Our Ref: 718742  
DPIE Ref: DA220-07-2002-I-Mod-12  
RFI Ref: RFI-35384212

**RESPONSE TO REQUEST FOR ADDITIONAL INFORMATION – MODIFICATION TO DEVELOPMENT CONSENT  
DA220-07-2002-I-Mod12, 1 DAMPIER STREET, BOWMAN NSW**

On behalf of the applicant, Teys Australia Southern Pty Ltd, please find below a formal response to the request for additional information provided by the Department on 01 February 2022. The below response adopts the points outlined within Attachment 1 of the request.

35A201 - 15
NOT FOR CONSTRUCTION

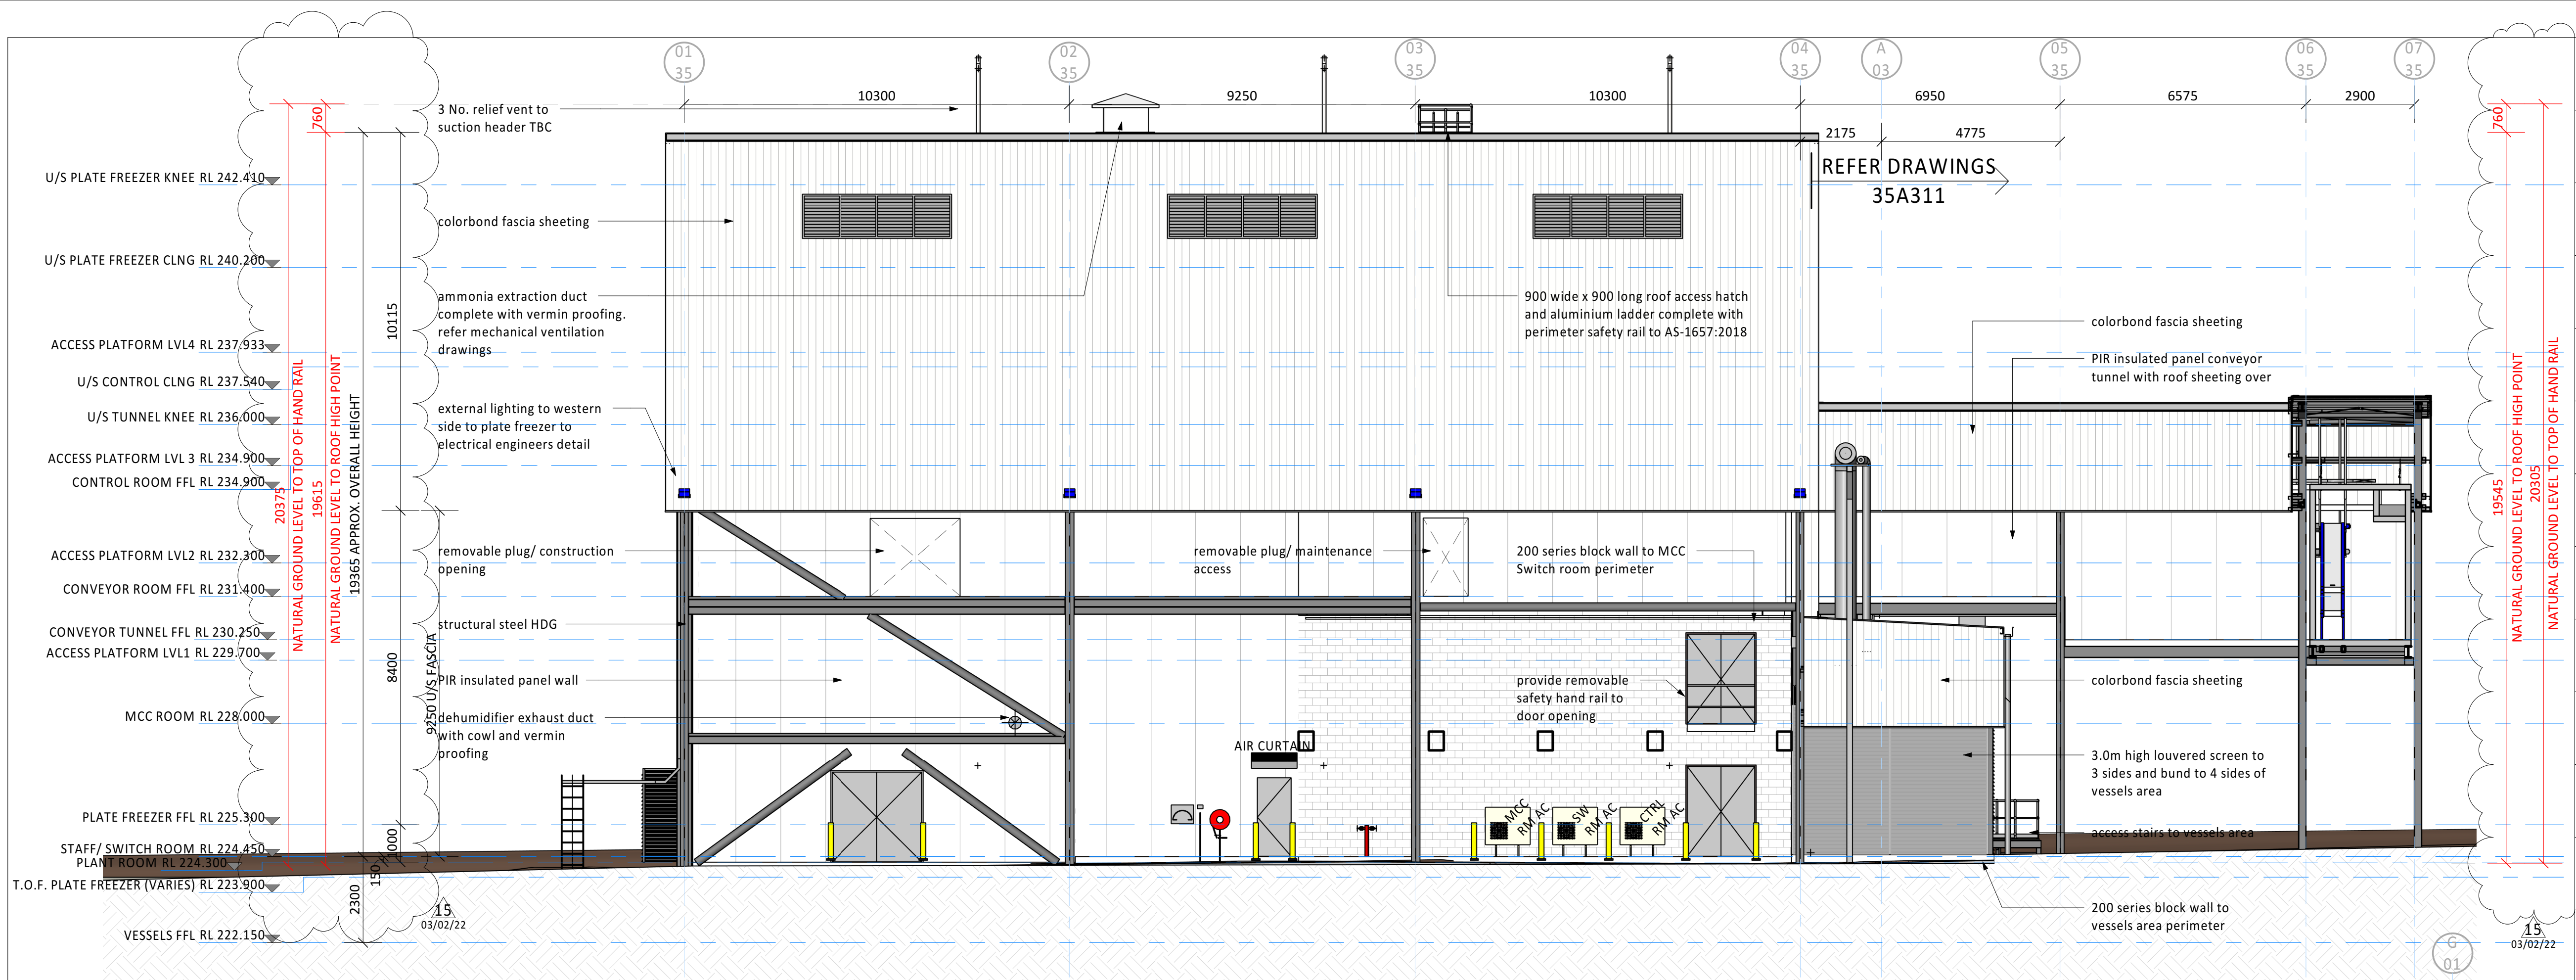
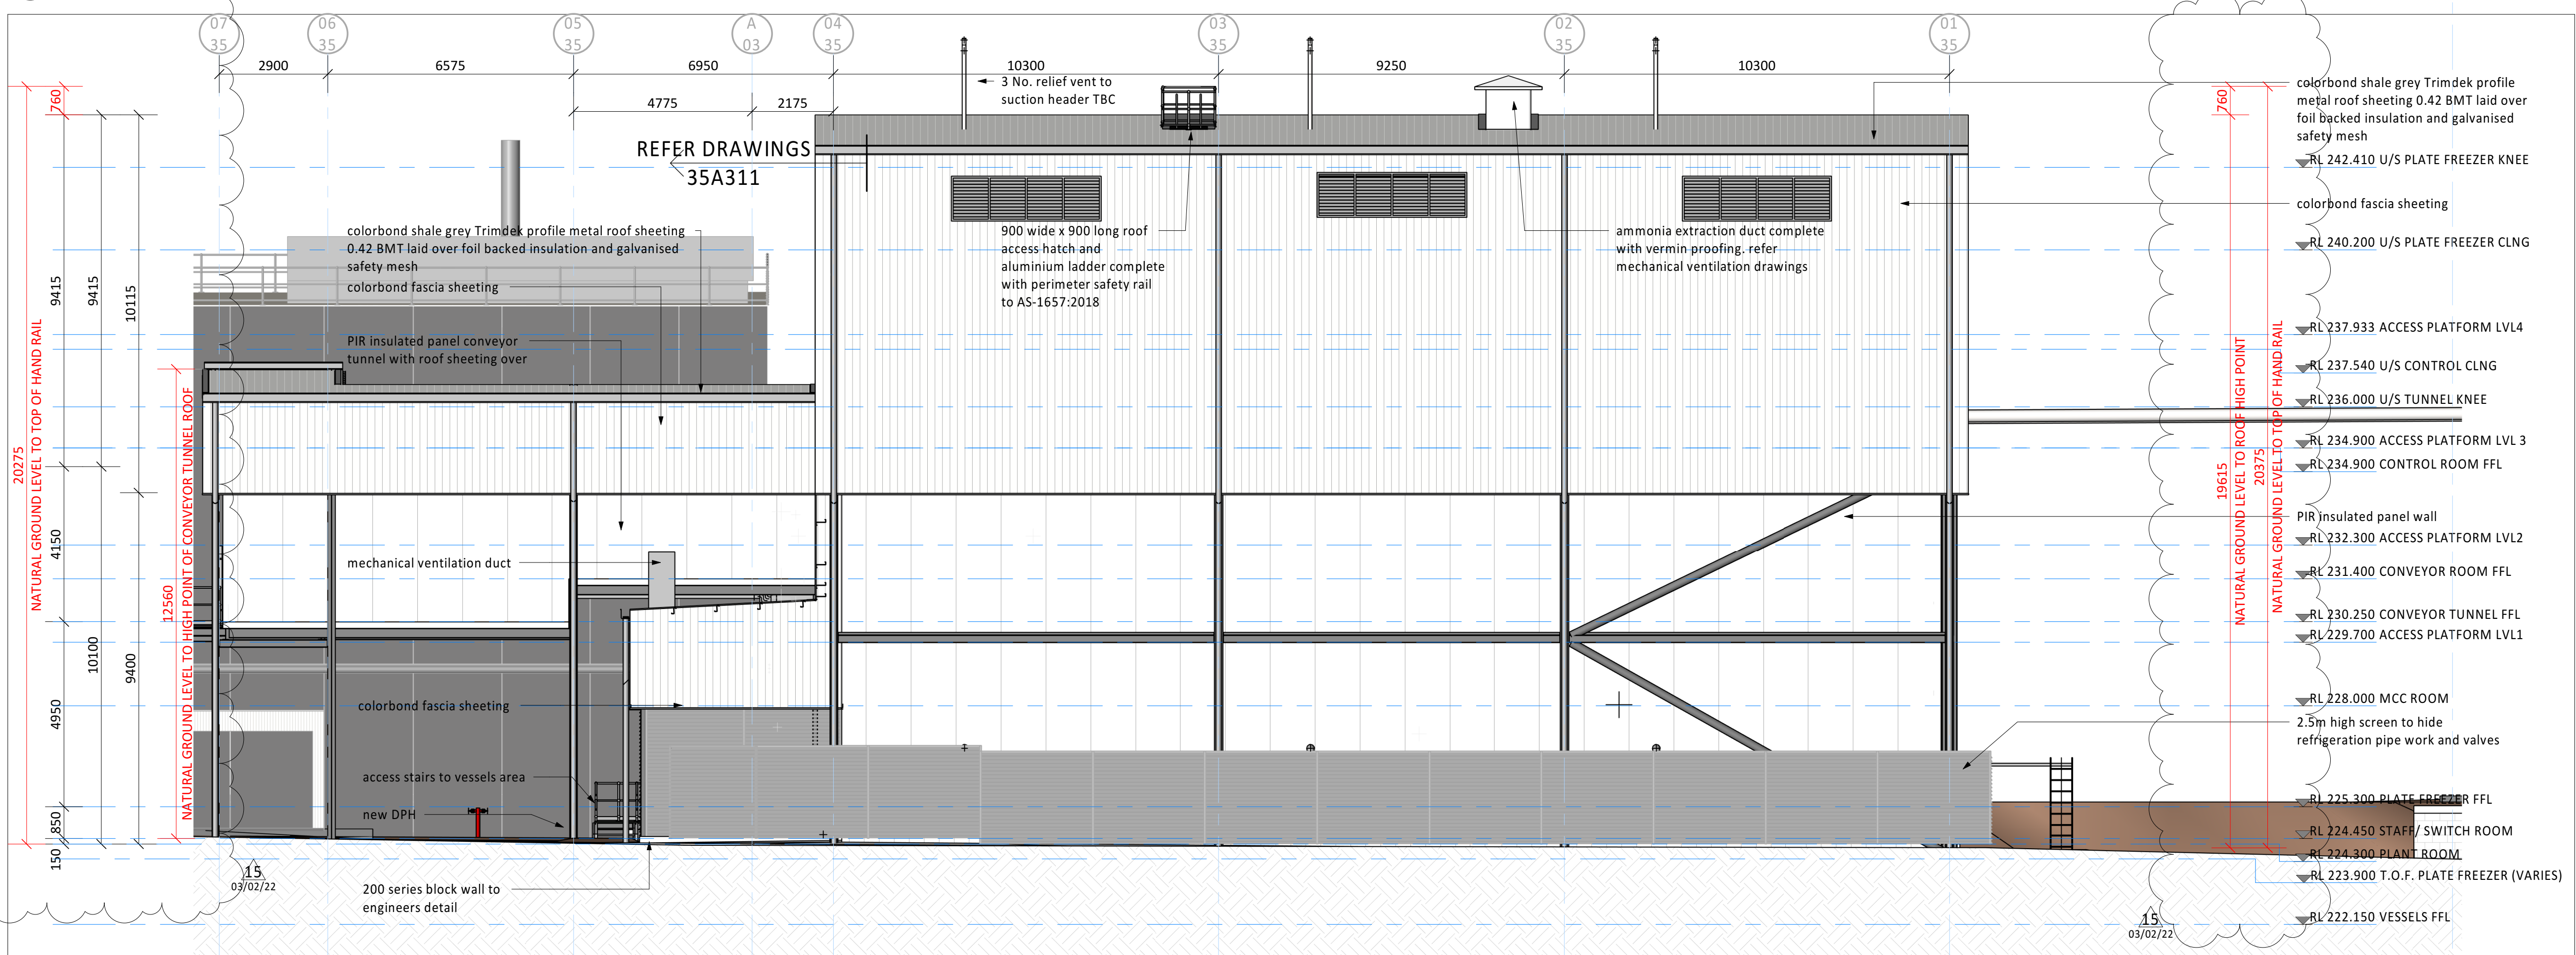
The Report states that the building height of the proposed Plate Freezer building is 18.15m. Upon evaluation of the submitted drawings the proposed Plate Freezer building is higher than stated. Elevation plan (plan No. 35A201-7) shows a maximum building height of 18.15m, however this height is measured from RL225.3 (freezer plates) not from the ground level (existing). Please clarify this discrepancy.

The height measurement has not included the indicative rooftop plant envelopes nor safety rails shown in the architectural plans. The Report is required to be amended to ensure the accurate building height is provided in accordance with the 'building height' definition included in the Wagga Wagga Local Environmental Plan 2010.

Elevation Plans have been provided to provide further clarification. The Elevation Plans confirm the building height, at its highest point, will be 20.375m (natural ground level to top of handrail).

35A301 - 16

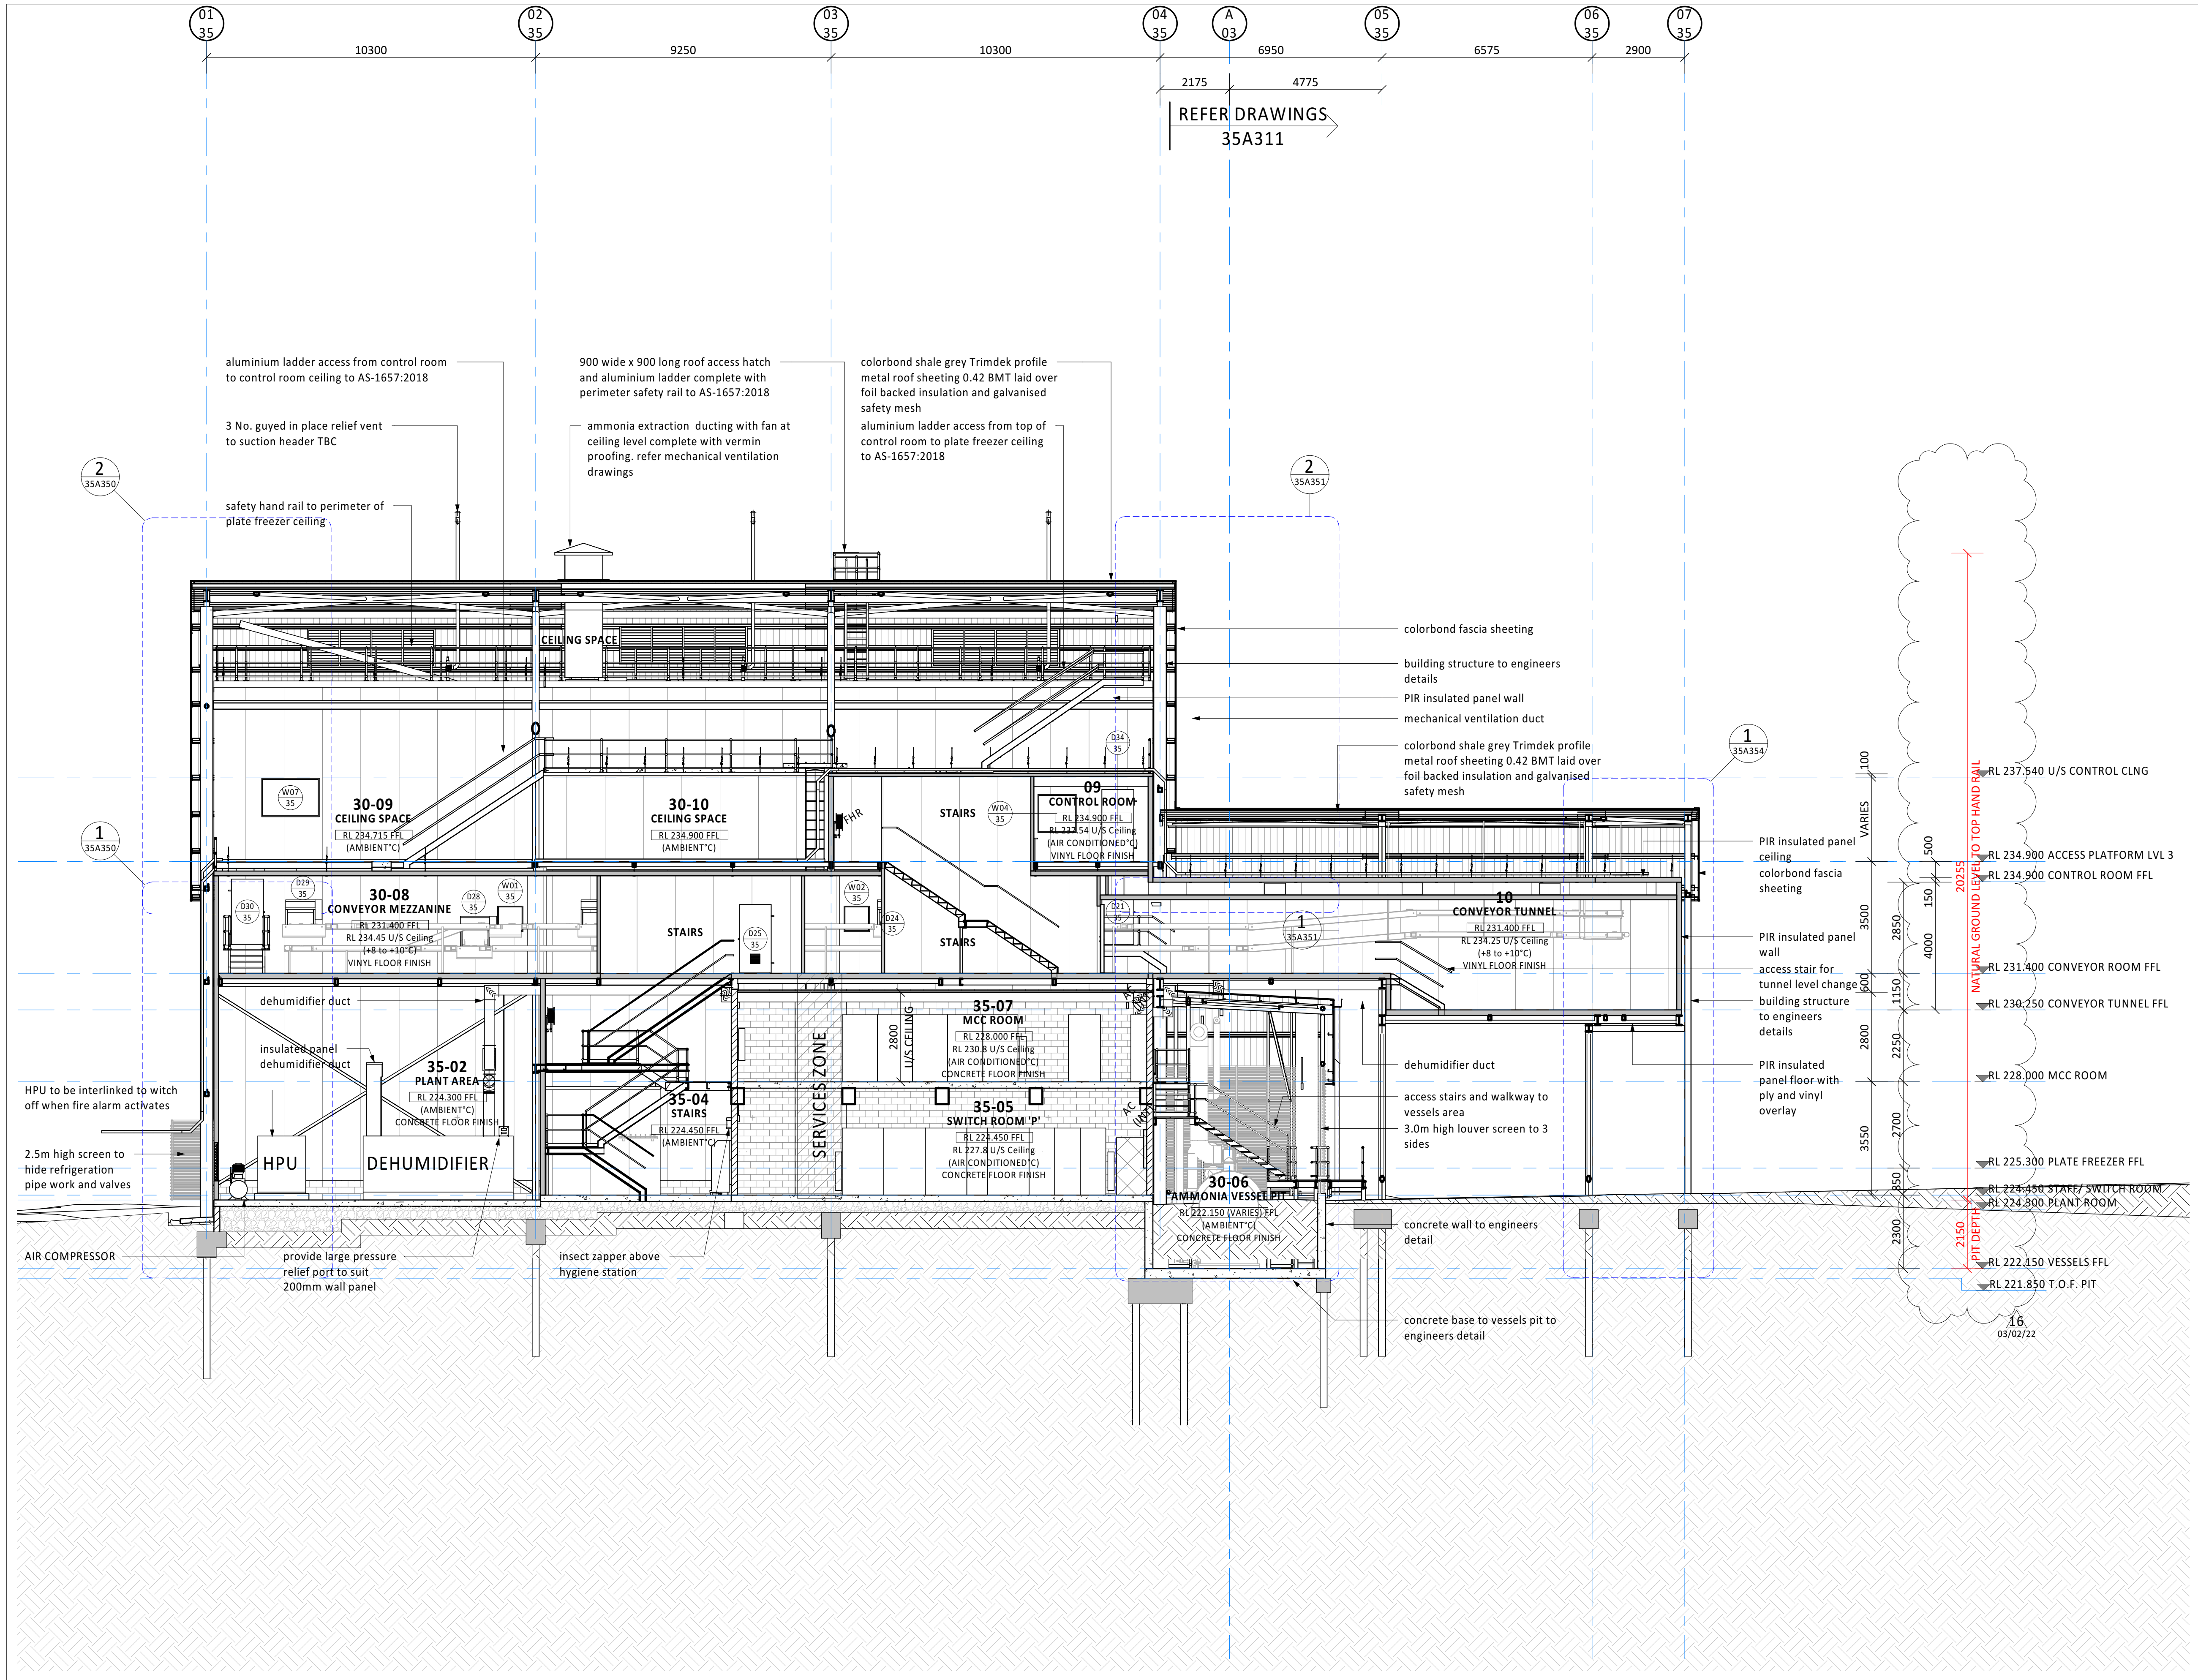
No reference is made in the Report as to the excavation required to facilitate the “ammonia vessel” footprint as demonstrated in section plans No. 35A301.8 & 35A302.1. The excavation is demonstrated at up to 3.75m below the ground level. Further details on the proposed excavation and information referencing the provisions of State Environmental Planning Policy No 55 – Remediation of Land (SEPP 55) is to be provided.

The Modification Report has been updated to provide additional details regarding the ammonia vessel. As the proposal relates to development over a brownfield area of the site a contamination report is not deemed necessary. Contamination would have been appropriately considered as part of the original development application or subsequent modifications where relevant to the area of interest. The ammonia vessel will be designed and constructed in accordance with relevant Australian Standards. The pit will be constructed from reinforced concrete walls and base slab with ‘Xypex’ additive. This will make the pit impervious to water ingress and egress of possible contaminants.
